Lime Down

Solar Park

Statement of Common Ground with Environment Agency

Document Reference: EXAM/8.6

Title:
Figure 9-9-6: Watercourse Crossing
Schedule: Cable Route Corridor

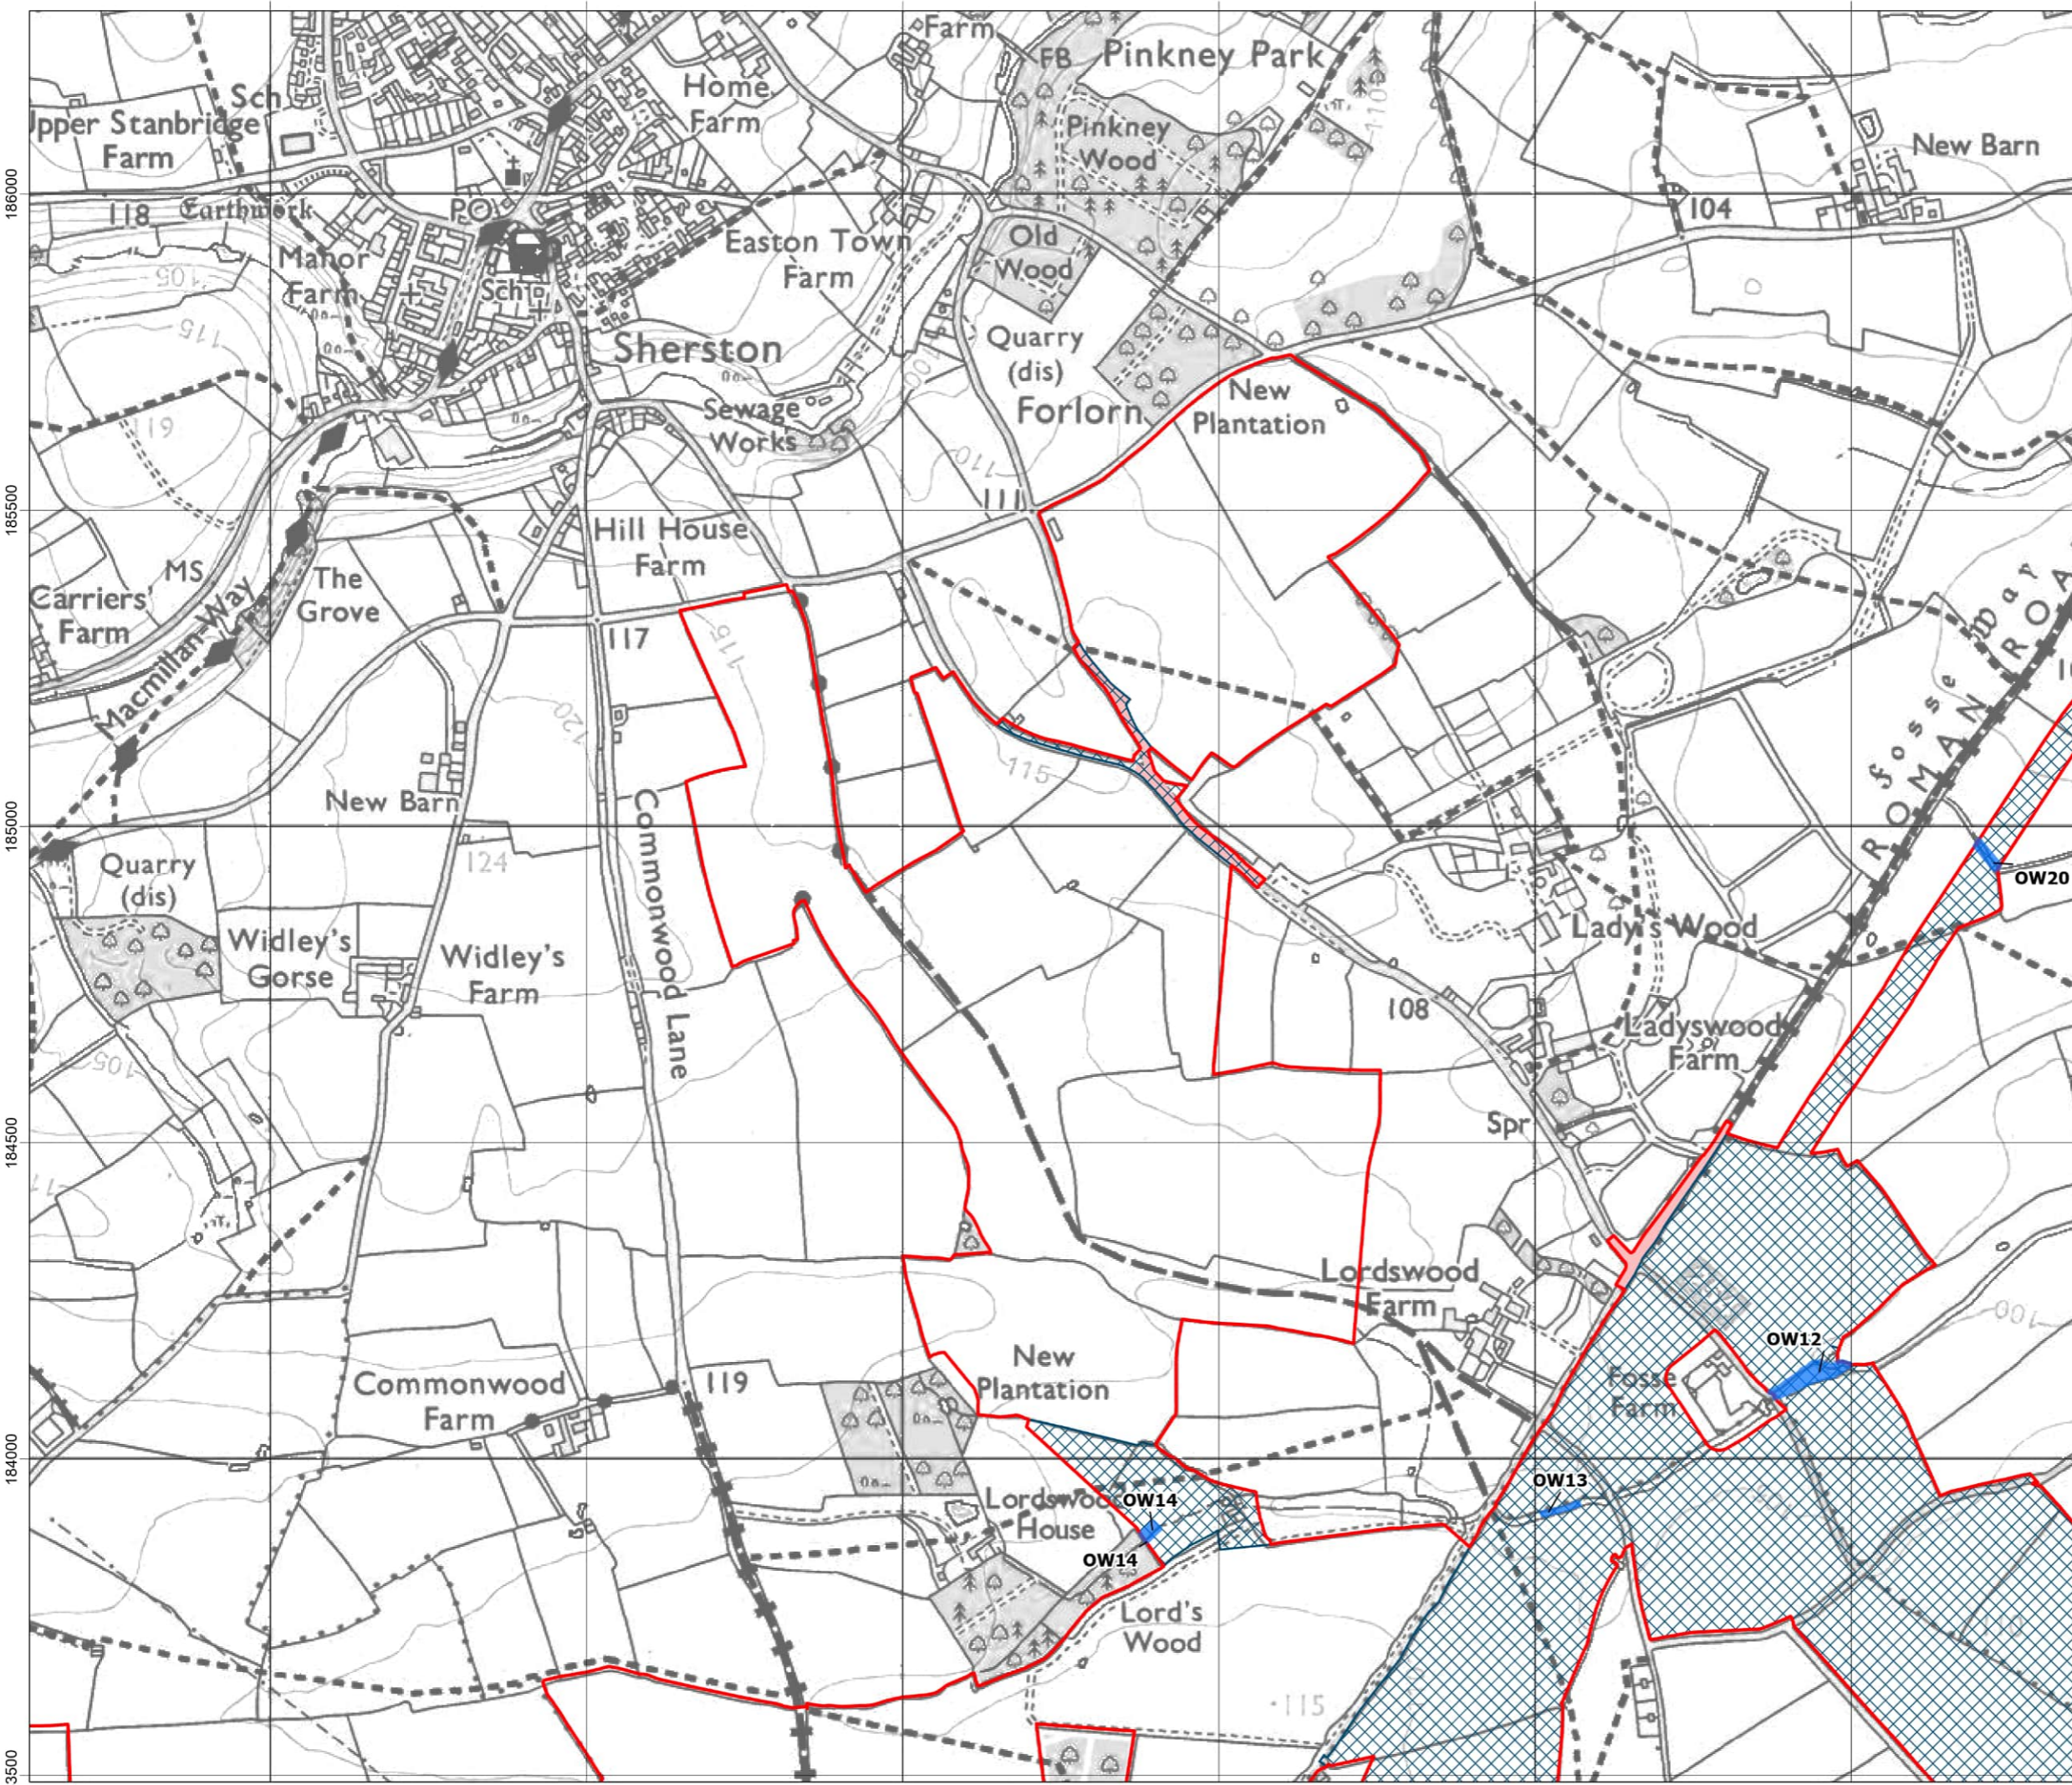
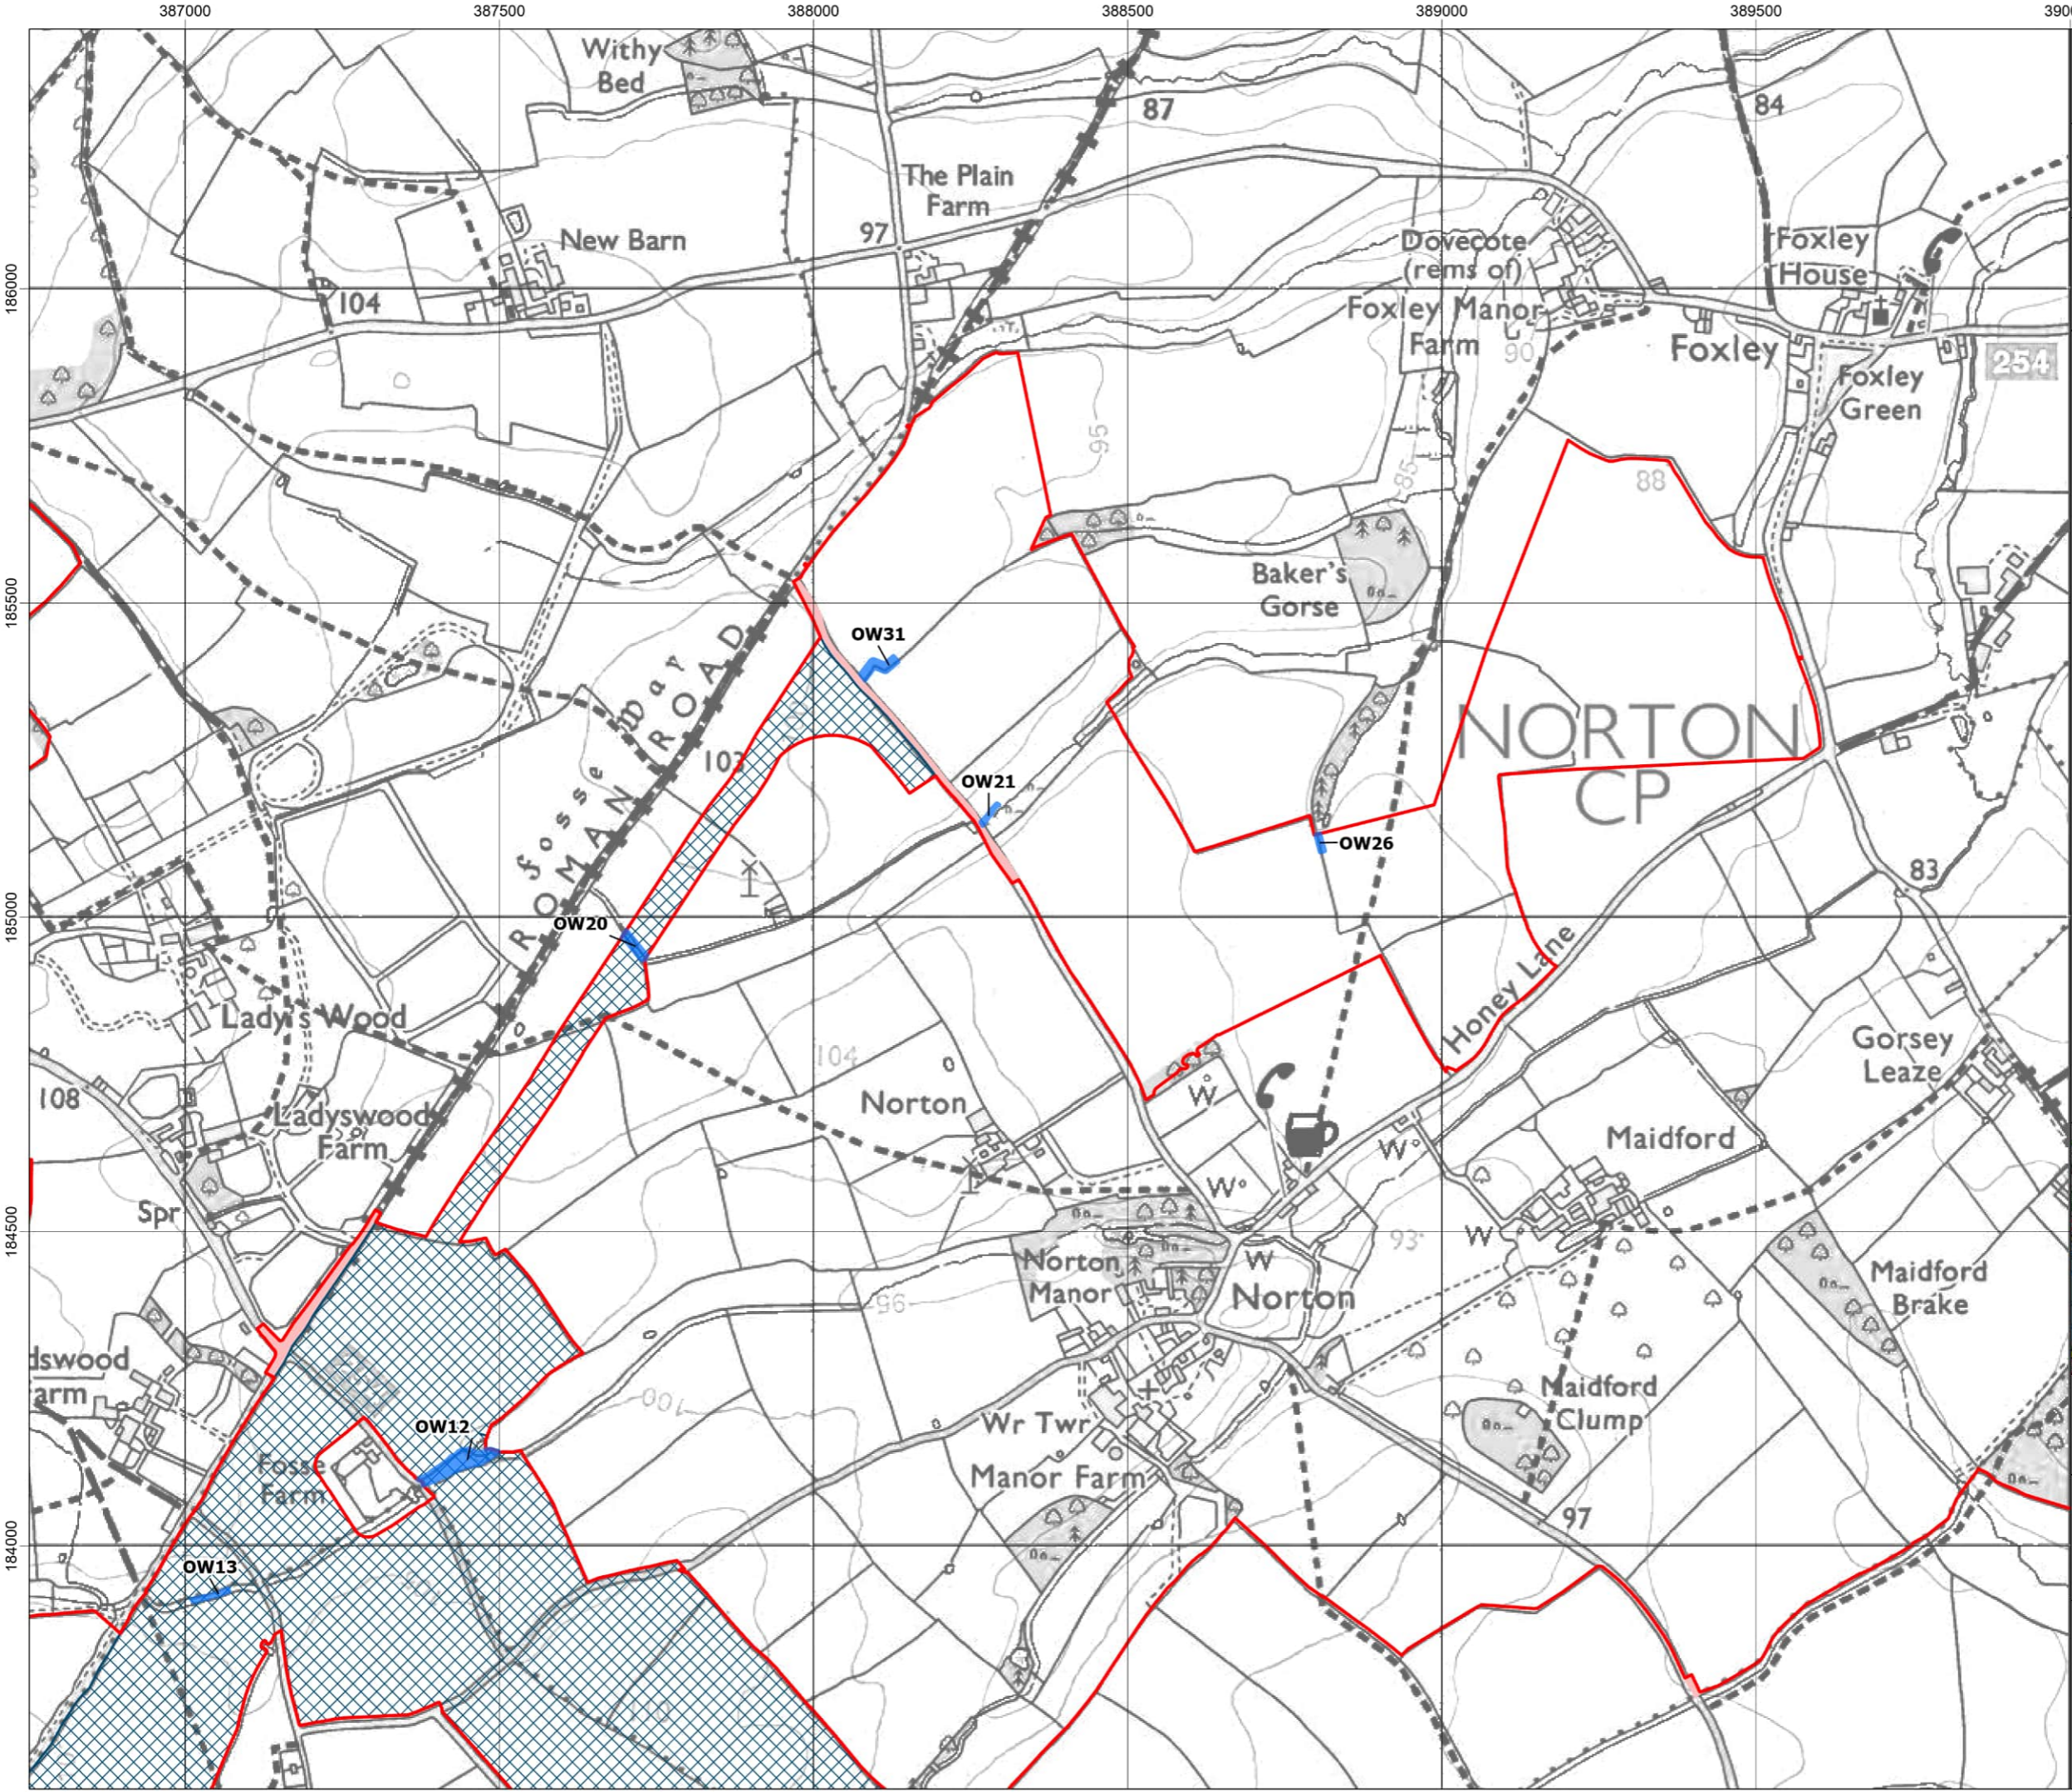
Reference	Sub-topic	EA Position	Applicants Position	Status
3.1.12	Ecological impact from watercourses crossing	<p>Due to the lack of habitat descriptions or photographs of watercourses and the reference to the use of open cut technologies on SM5 (not referenced elsewhere) in Appendix 11-1 Flood Risk Assessment and Drainage Strategy – Lime Down Covering Report; Table 5: Watercourse Crossing [APP-210], the EA is concerned that the ecological impact of these crossings has not been fully assessed and/or communicated in Chapter 9: Ecology and Biodiversity [APP-061], regarding impacts on habitats and associated species.</p> <p>Whilst we agree with the detail set out in paragraph 9.1.47 of Chapter 9 Ecology and Biodiversity [APP-061], there remains a risk that some watercourses where an open-cut method is selected could have a significant impact on fish species—not only eels and brown/sea trout. Of particular concern are crossing reference SM3 and SM5 which are both main river and may provide suitable habitat for fish.</p>	<p>A new appendix to ES Volume 3, Chapter 9: Ecology and Biodiversity was submitted at Deadline 1 which provides habitat descriptions and photographs of all watercourse crossing points, as well as the construction methodology to be used at each crossing point, for clarity.</p> <p>ES Volume 1, Chapter 9: Ecology and Biodiversity [REP1-015] has been revised to include a separate section for Aquatic Invertebrates (excluding white clawed crayfish, which is covered in its respective section), and additional text has been included on aquatic macrophytes within existing sections relating to plants. No significant residual adverse effects are anticipated for either of these species groups, and the revised Chapter was submitted at Deadline 1.</p> <p>Notwithstanding, the Applicant confirms that no watercourse crossing is proposed at SM5 and this has now been removed from the watercourse crossing schedule. This does not alter the assessed flood risk, drainage or ecological conclusions. The Applicant</p>	Under Discussion

Reference	Sub-topic	EA Position	Applicants Position	Status
		<p>The Environment Agency requires the applicant to provide a clear plan and schedule detailing extent and nature of works directly impacting upon watercourses. Provide habitat descriptions and photographs of proposed watercourse crossings and ensure Chapter 9 Ecology and Biodiversity [APP-061 assesses the impact of these, with other documents updated as appropriate.</p> <p>This would provide confidence that the chosen crossing type is appropriate.</p>	<p>will update the relevant application documents as set out above.</p>
